City of Albuquerque

April 21, 1993

RE: DRAINAGE PLAN FOR TIRE PLUS ADDITION (J14-D104) ENGINEER'S
STAMP DATED 4/13/93.

**TIRES PLUS ADDITION**  
GRADING AND DRAINAGE PLAN

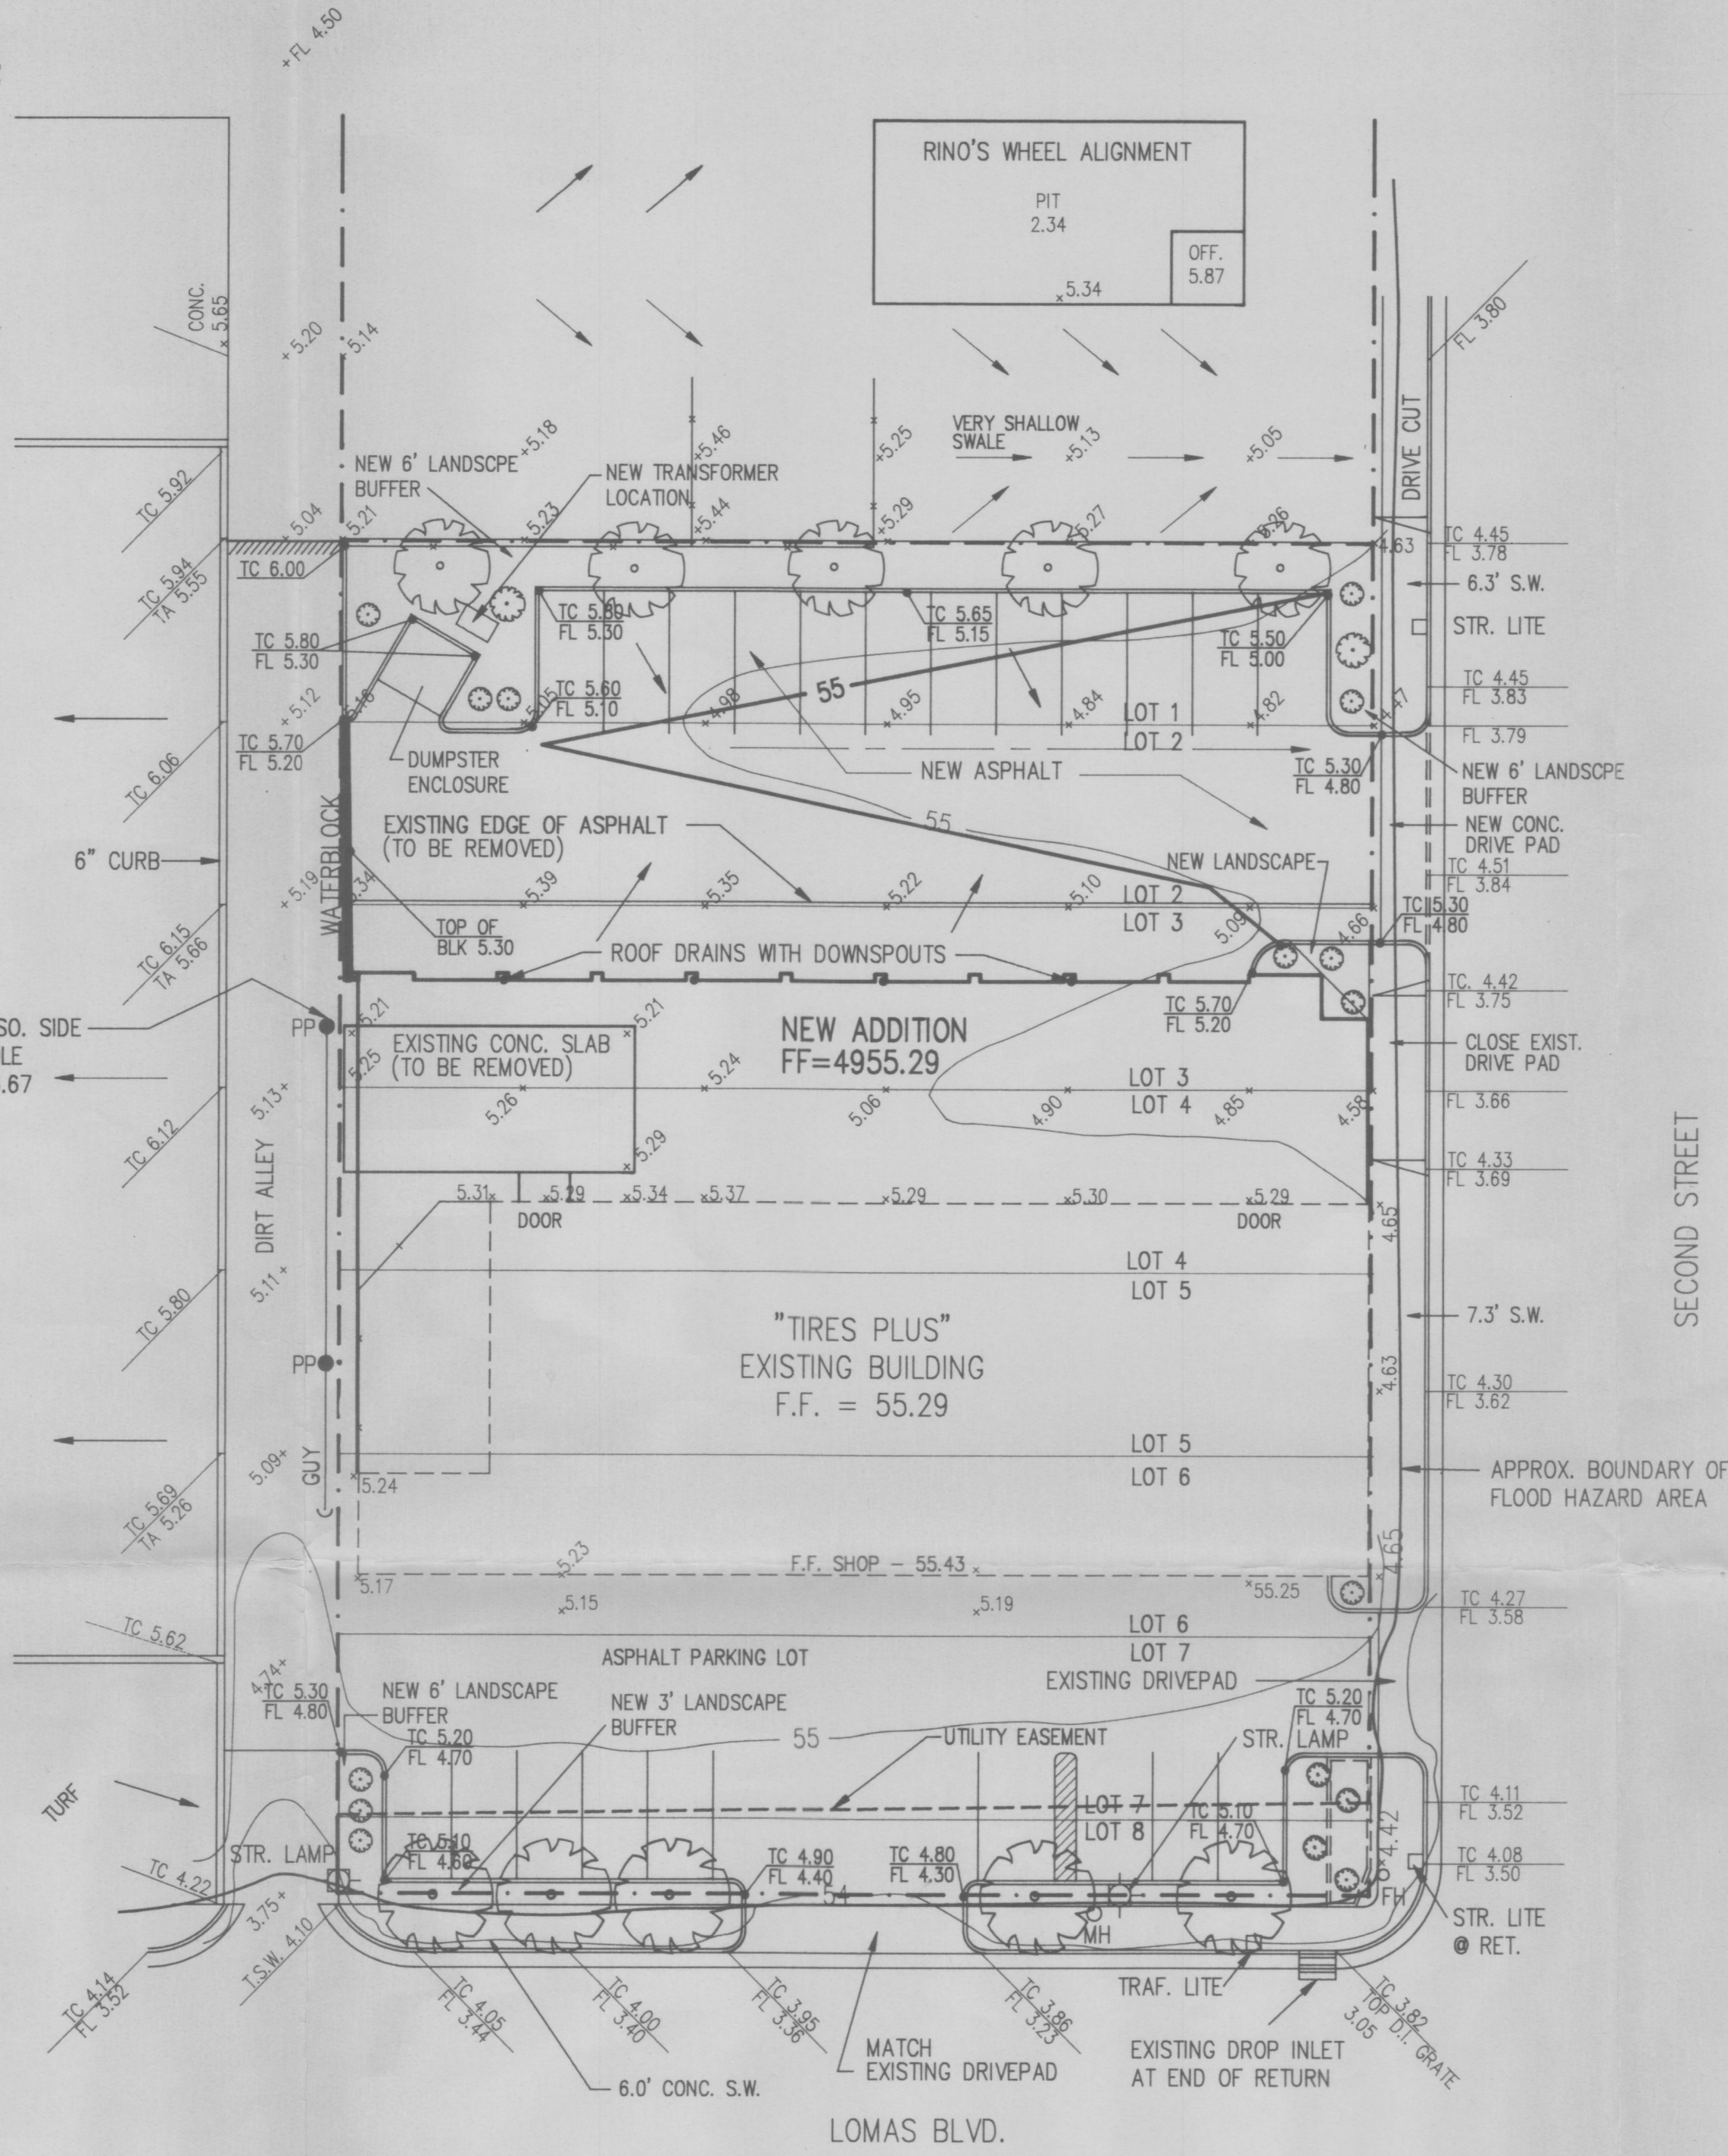
1. Elevation at property line must be 1' foot above the flowline elevation. Critical points are at the driveways, a one foot water block is required.
2. Please indicate the flood zone encroachments on the plan drawing.
3. alley construction must be processed through D.R.C.
4. Location and direction of roof drains.
